**From:** KARL.P.Turton@met.police.uk  
**Sent:** 09 February 2024 09:59  
**To:** Harry Mifsud  
**Cc:** Jonathan Lisseter  
**Subject:** RE: Hartley Centre: Gates and Signage  
**Attachments:** EXP-Protected-Exit-Button-Devices-808284-150122.pdf

**From:** Harry Mifsud <HarryMifsud@hill.co.uk>  
**Sent:** 06 February 2024 15:23  
**To:** Turton Karl P - Continuous Policing Improvement <KARL.P.Turton@met.police.uk>  
**Cc:** Jonathan Lisseter <JonathanLisseter@hill.co.uk>  
**Subject:** Hartley Centre: Gates and Signage

Title.		Surveyor	
Hartley Centre - Security Gates		—	
Drawing No.		Drawn	Chk
12137		DWC	—
Revision		Date	Scale
C01		Jan 24	—
Sheet		Angle	
1

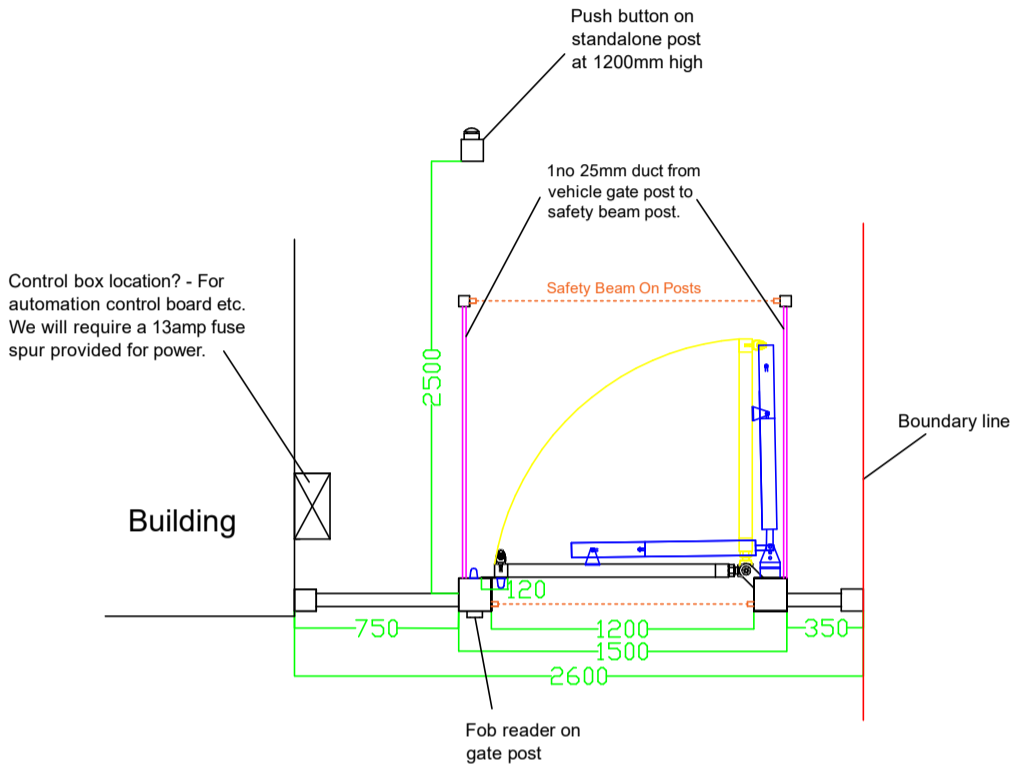
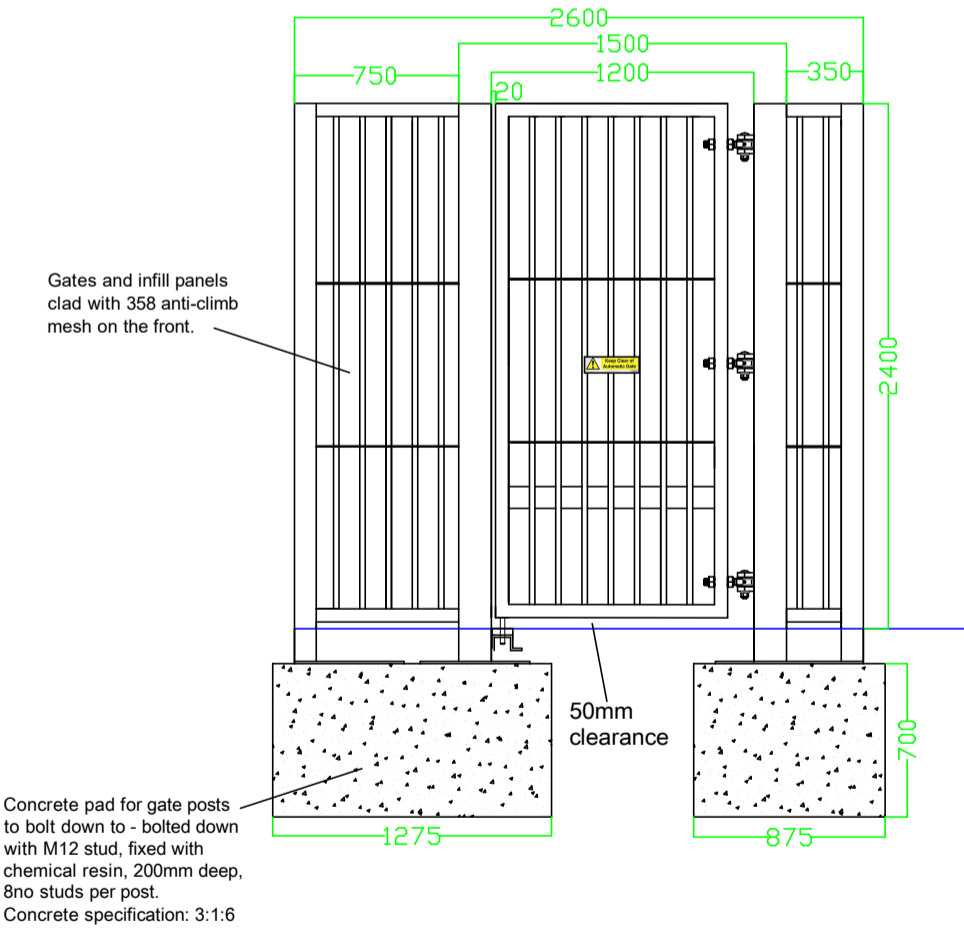
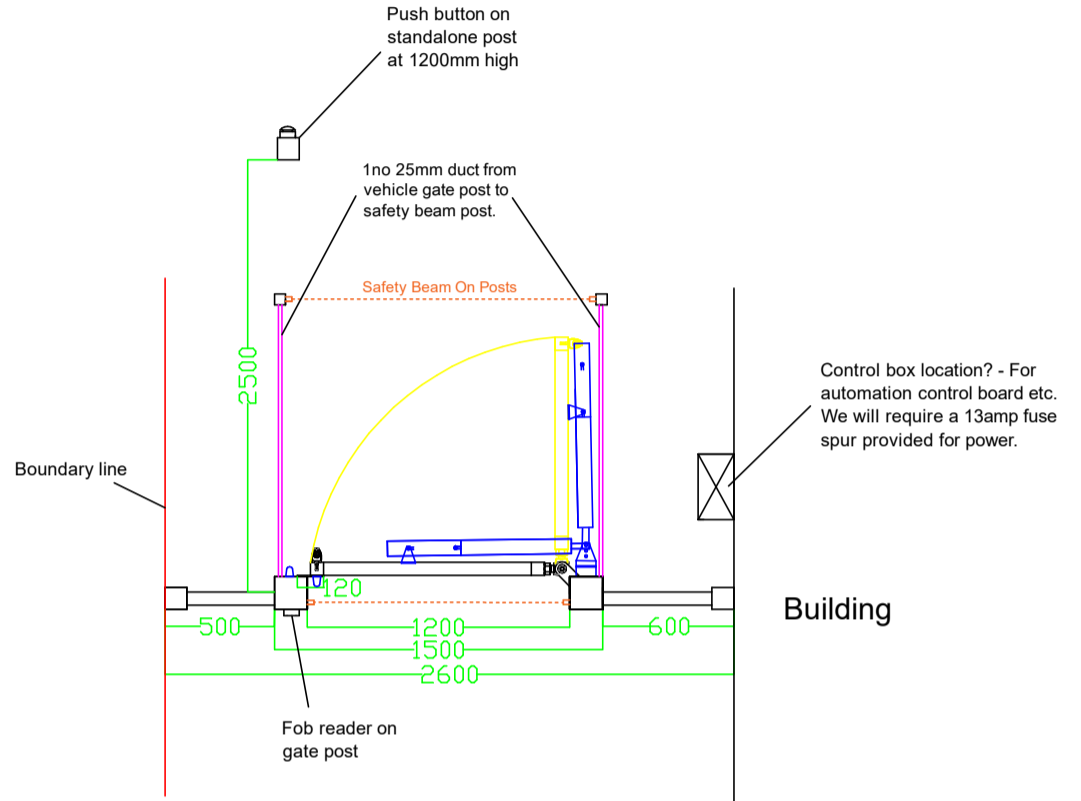
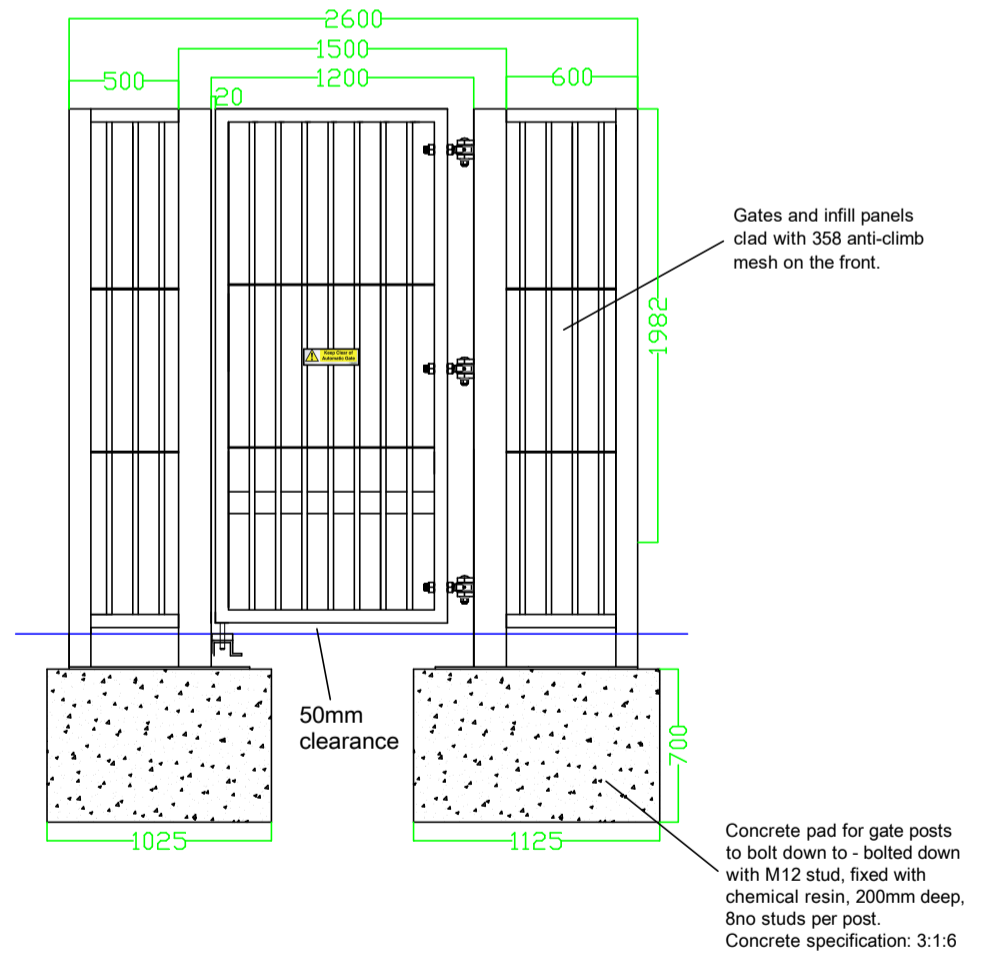
Good morning Harry,  
All the gates appear spot on, I will add these to the file.  
Here are those protected PTE buttons, either is fine. If you have another provider – that's fine too. Just need them to do the same job.  
See what works best for you.  
Kindest regards Karl.
